Application No: H11-0172-26 **Applicant:** Mr & Mrs Richardson

Proposal: Details of confirmation showing that approval has been granted by South Holland Internal Drainage Board in relation to Byelaw 10 (Condition 4 of H11-0815-25)

Location: 19 Highgrove Long Sutton Spalding

TITLE
Existing Block Plan
Proposed Block Plan

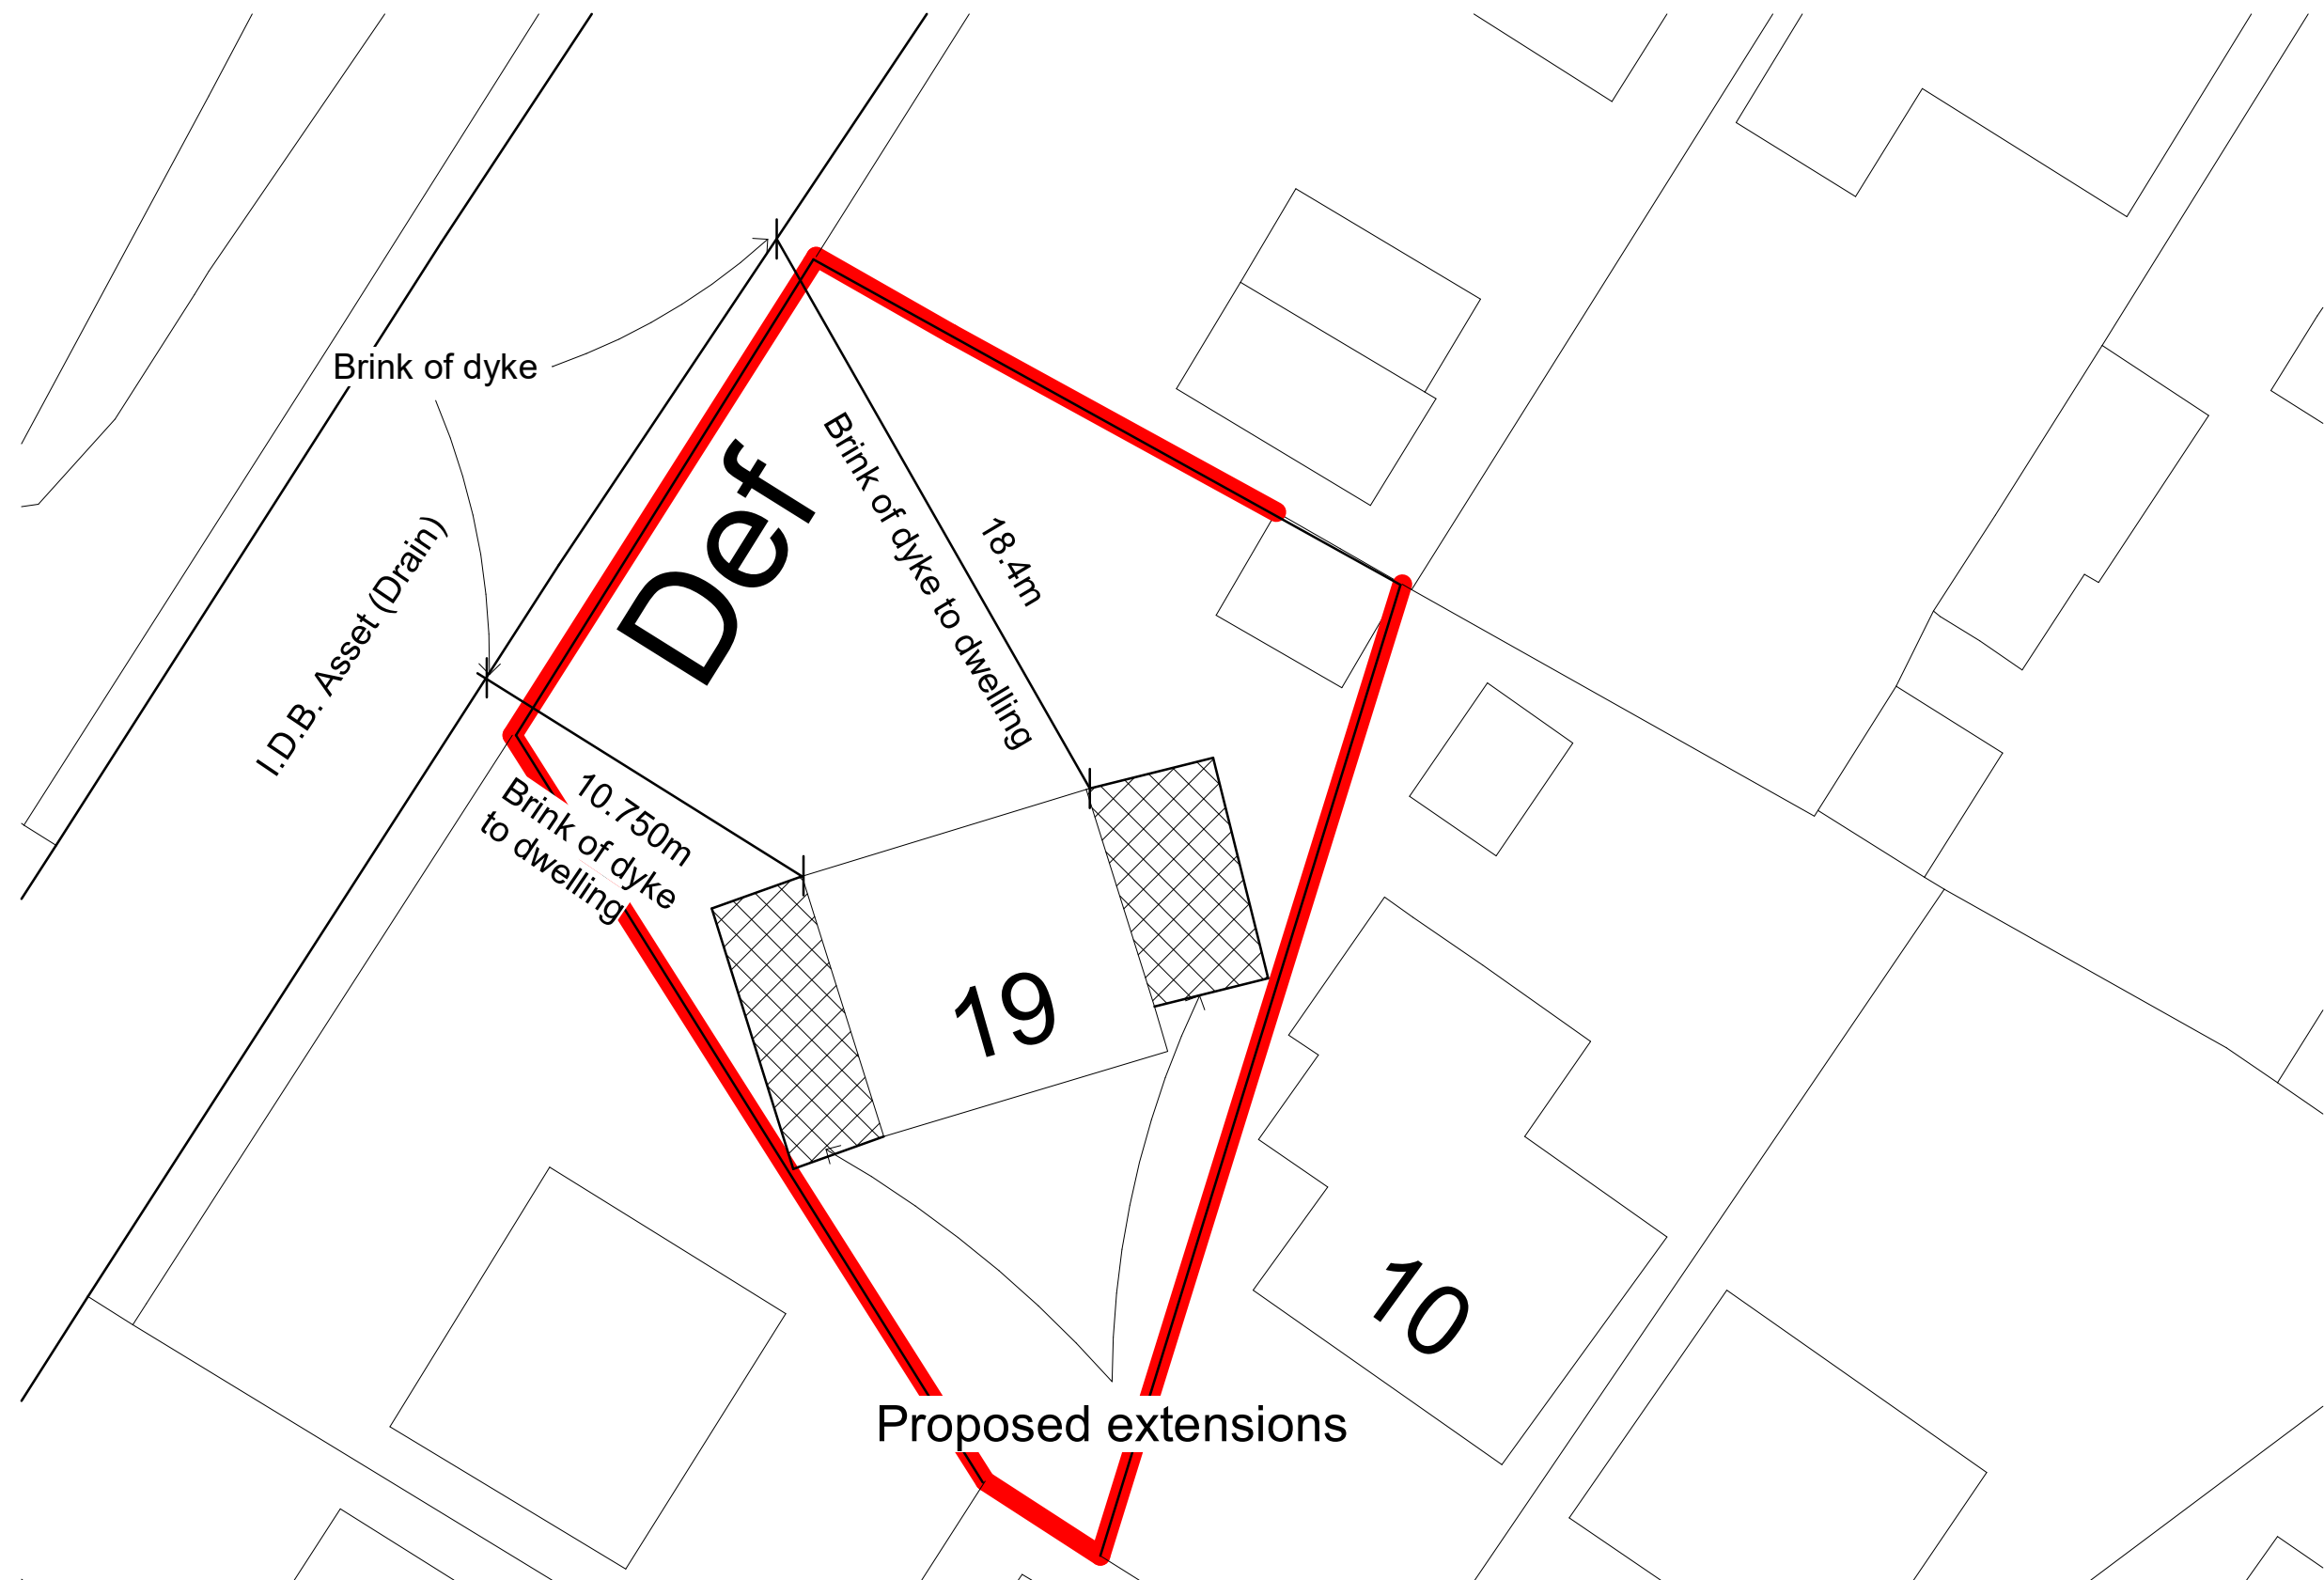
Within this discussion, the IDB outlined that they object due to the plans showing that the works would be located within 9 metres of the Board watercourse and therefore needing consent under Byelaw 10. A site visit took place between the IDB and agent in which they confirm that the extension would be outside the Boards 9 meter Byelaw zone.

It was explained to the agent that they would need to provide a plan which shows that the extension is outside of this 9 metre zone, however such a drawing was shown as part of this submission and as such the IDB have an objection on this basis.

To resolve this issue and allow for the condition to be discharged without further delays, correspondence took place. From this, the IDB have agreed to remove their objection on this occasion on the basis that no part of the extension will be installed within 9 metres of the Board arterial watercourse. The applicant is reminded that any works that are installed without the Board's prior written consent may result in enforcement action being taken against them.
